**RE: Harnett County Land Use Application HTE #07-5-16784R Magnolia Crest Lt 5**

Several attempts have been made to evaluate your property for the purpose of issuing an Operation Permit. The evaluation could not be completed for one or more of the following reasons:

James E. Manhart, R.S.  
Environmental Health Specialist  
Harnett County Department of Public Health  
Environmental Health

Operation Permit

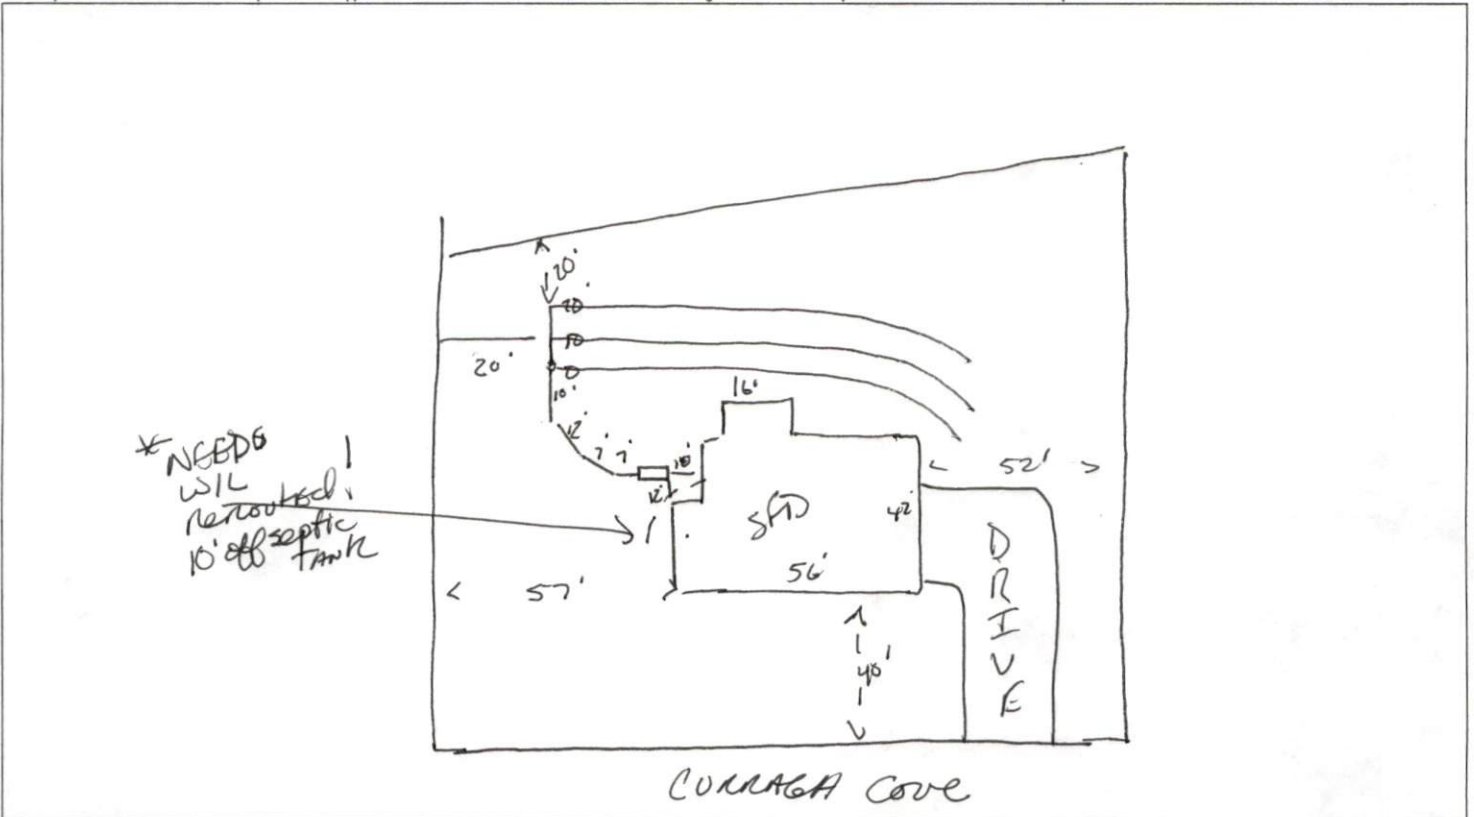
- 1. Property lines/corners not marked or labeled
- 2. House corners not marked or labeled
- 3. Directions not clear to property
- 4. Property needs brush or vegetation removed
- 5. Backhoe pits required
- 6. Other ***It is required that you show proof that the water line is 10' from the septic tank and/or lines. Until you give proof of this, I cannot issue an Operation Permit.***
